**Addendum No. 1**

RE: Contract # C204396

**Edgecombe & Nash Counties (I-6046)**

US-64 (FUTURE 1-87) FROM SR-1603 (OLD CARRIAGE RD) TO SR-1225  
(KINGSBORO RD)

TYPICAL SECTION NO. 4  
US-64 @ I-95 CD LANE

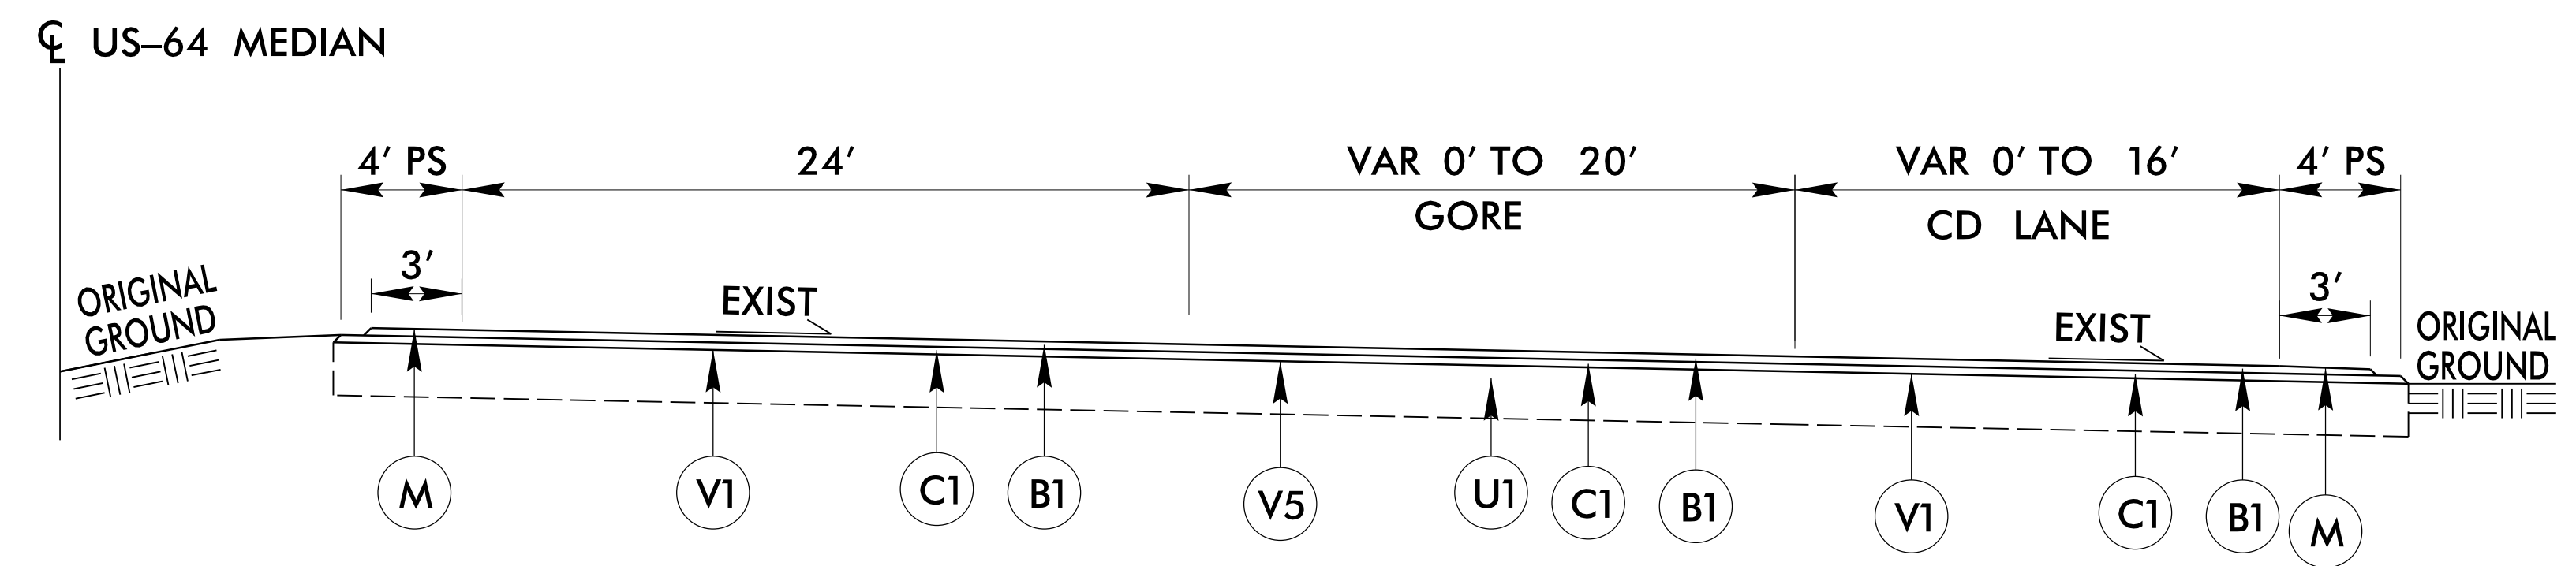
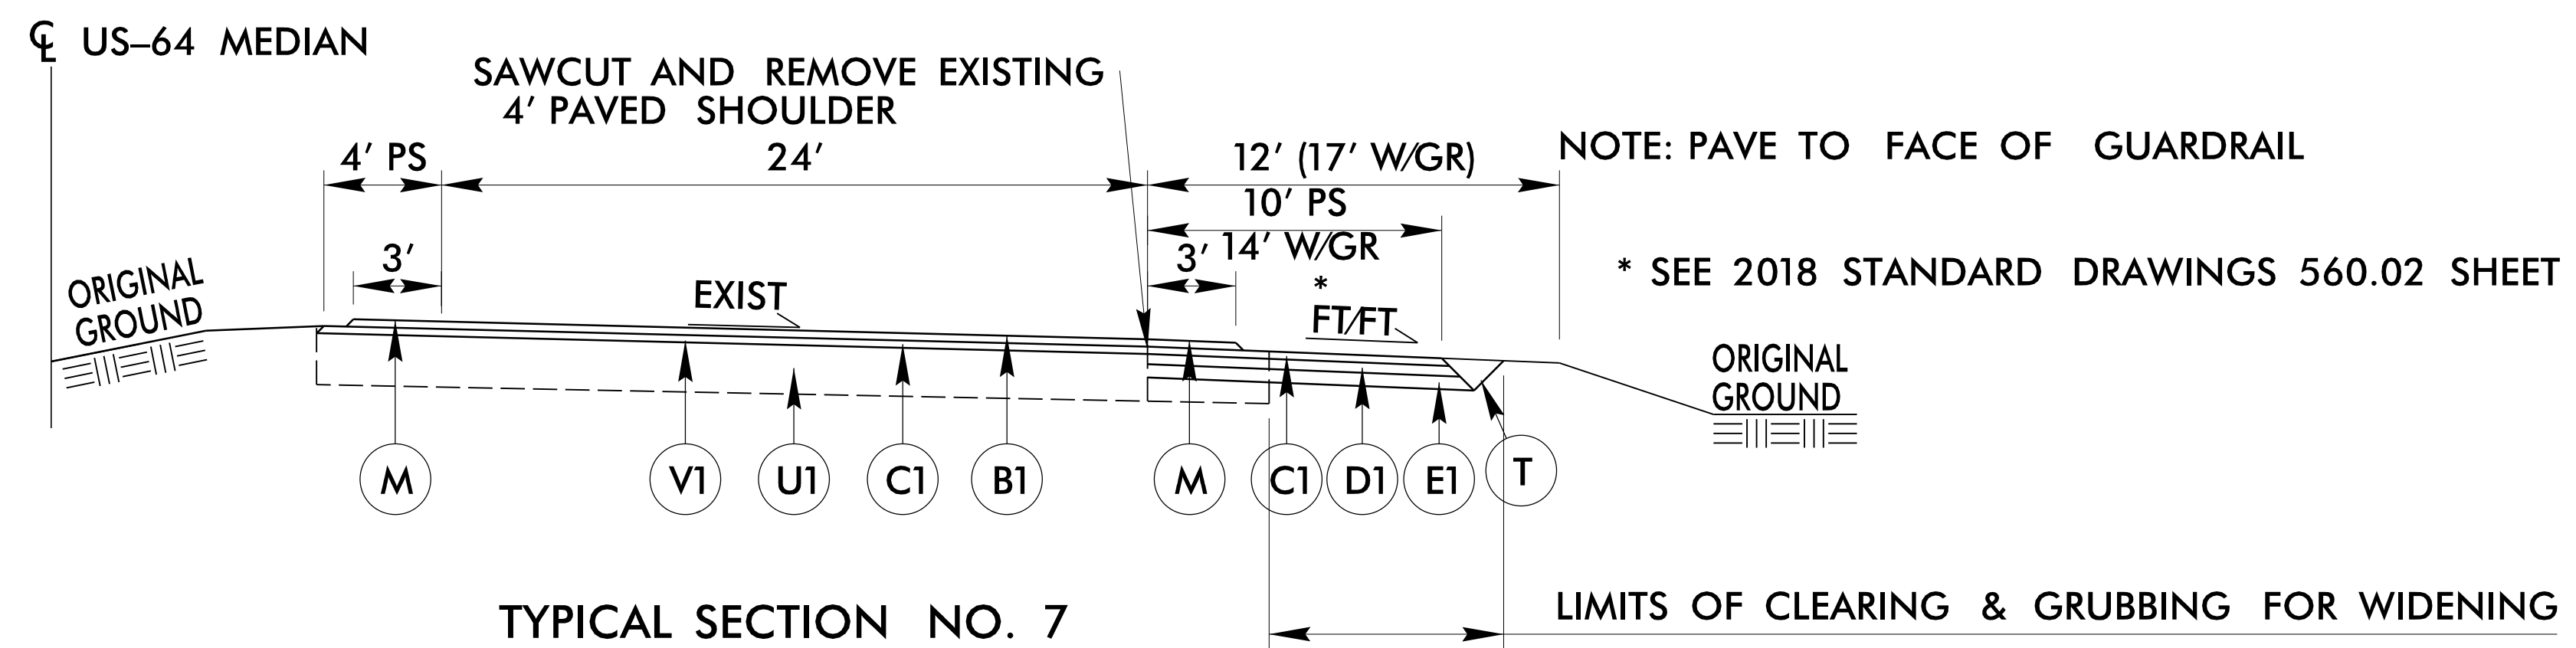
Sheet No.	Revision
5	Typical Sections No.1 & No.2 have been revised
6	Typical Sections No.4 & No.7 have been revised
11 thru 30	Summary of Quantities revised to reflect quantity changes shown below
